DECISION DELEGATED TO HEAD OF PLANNING

Application No: H16-1096-25 **Applicant:** Mr A Piccaver

Proposal: Replacement of windows at first floor level, access door to ground floor & removal of window to ground floor

Location: 2 & 2a Sheep Market Spalding Lincolnshire

Existing Ground Floor Plan
Scale 1:50

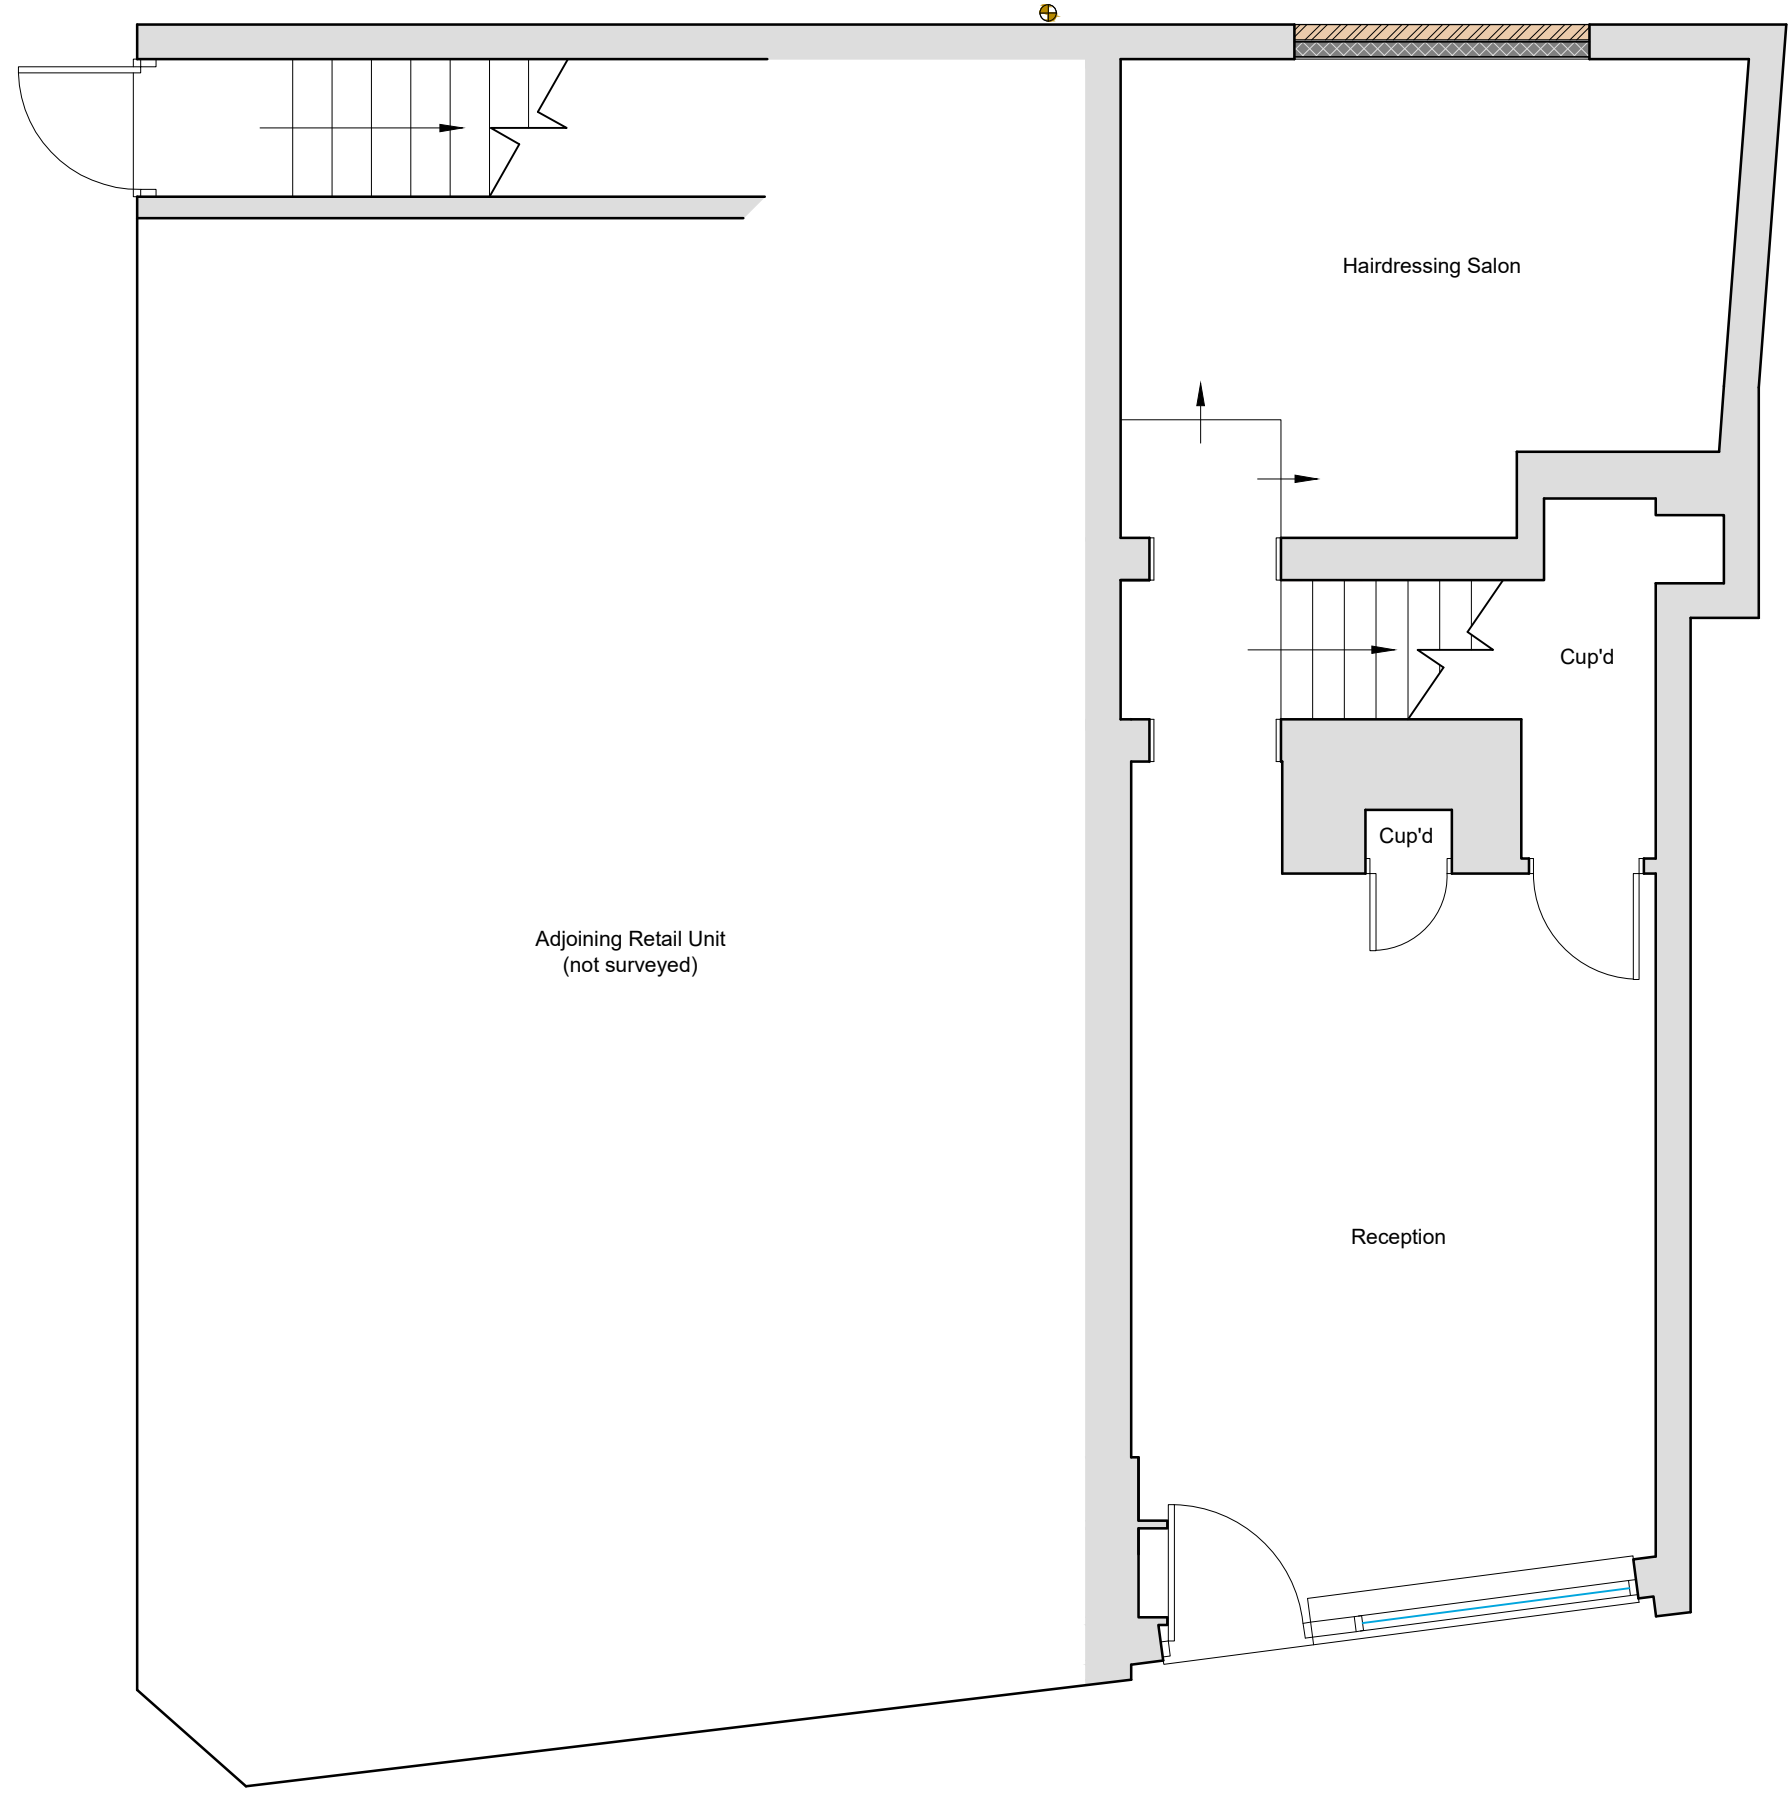
Spalding and District Civic Society: There are no frame or casement details of the windows proposed. Timber would be preferable to UPVC in such an important position in the town. The existing fenestration is unfortunate but there is no point in trying to make it look traditional in appearance.

Conservation Officer: As this application is solely for the replacement of windows, and situated in a prominent, conservation area location, full details of the proposed replacement windows shall be required prior to a decision. As the application currently stands, it is not possible to make a reasoned and informed planning decision with the detail available.

The application seeks consent to install flush casement UPVC windows at the first-floor level of the building and to replace a ground floor timber door on the north-eastern side elevation with a grey composite door. The windows at the ground floor level would remain unchanged.

It is also proposed to remove a window on the rear (south-eastern) elevation and infill this area. It is presumed that this area is proposed to be infilled with brickwork; however, the submitted plans do not conform this. As the rear elevation is not visible from the street scene nor is it prominent within the Conservation Area, the proposed infilling of the window is considered to be acceptable, providing the infilled area match the existing elevation materials as closely as possible.

Currently, the windows on the front (north-western) elevation feature timber frames, the windows on the side (north-eastern) elevation feature UPVC frames, and the windows on the rear (south-eastern) elevation feature metal frames. The side and rear windows are not highly visible from the street scene. According to the submitted Planning Statement, as the windows are at the first-floor level, they are not in the "immediate view of people passing by"; however, the first-floor windows particularly at the front of the building are still clearly visible.

Policy 29 B(3) states that new development should seek to retain and reinforce local distinctiveness with reference to materials, amongst other factors. UPVC is not considered to be a local vernacular material. The council's conservation officer has asked for further information to justify the proposals; however, the only additional information received has been an updated plan clarifying the existing materials within the windows.

The proposed use of UPVC is not considered to be acceptable in this instance as the proposal would be contrary to Policy 29 of the Local Plan and Paragraph 215 of the NPPF. For example, Policy 29 states that new development should seek to retain and reinforce local distinctiveness with reference to materials. UPVC is not considered to be a local vernacular material. It is considered that the proposed use of UPVC would result in less than substantial harm to the character and appearance of the Conservation Area - albeit adverse harm would still result. It is not considered that there would be public benefits from the proposed change to UPVC windows and as such, the proposal would not accord with Paragraph 215 of the NPPF. It is considered that there is insufficient justification for the proposed change to UPVC windows and as such there are insufficient material considerations to weigh in weigh of the proposals due to the adverse impact that would arise to the surrounding built heritage environment. As such, the planning balance is against the development.
